From: ENVU Biodiversity and Land Use
Sent: 01 April 2025 08:31
To: Planning ContactCentre
Cc: Victor Grayson
Subject: 2024/93458 at location land at, Cliff Hill, Denby Dale, Huddersfield, HD8

BNG

FIGURE 02: EXISTING HABITATS PLAN

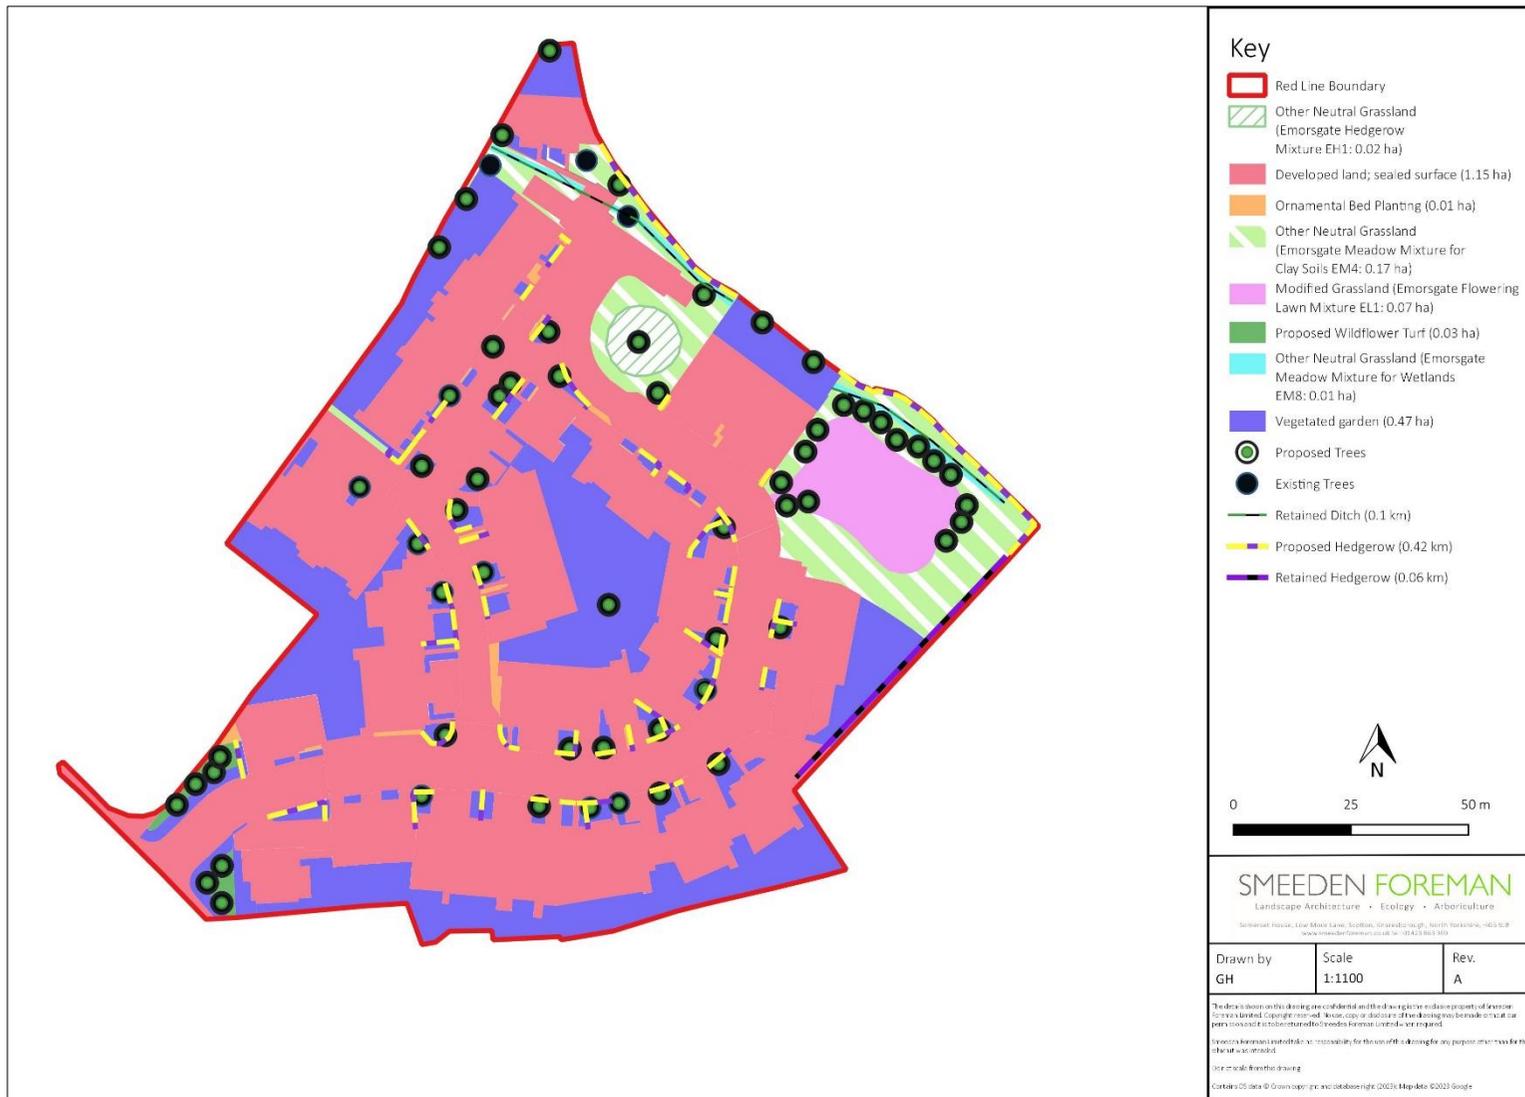
With regards to habitat units - this assessment shows a net loss, and the report shows no plan to make up for the shortfall. We recommend the applicant provides at least an outline of the intended route to achieving net gain. We need this information in advance of a planning decision because, if offsite gain is required, it will need to be secured with a section 106 agreement. If a section 106 agreement is needed, we recommend the applicant provides sufficient information for the heads of terms of an agreement prior to determination of the application

- A plan that follows the UK Habitat Classification showing the spatial locations of the habitats represented in the enhancement and/or creation tabs of the biodiversity metric (i.e. the target habitats).
- The georeferenced spatial data used to create both above plans (in either .shp or .gpkg format) and written permission to share this data with Kirklees Council.
- A 30-year Habitat Management and Monitoring Plan (HMMP)
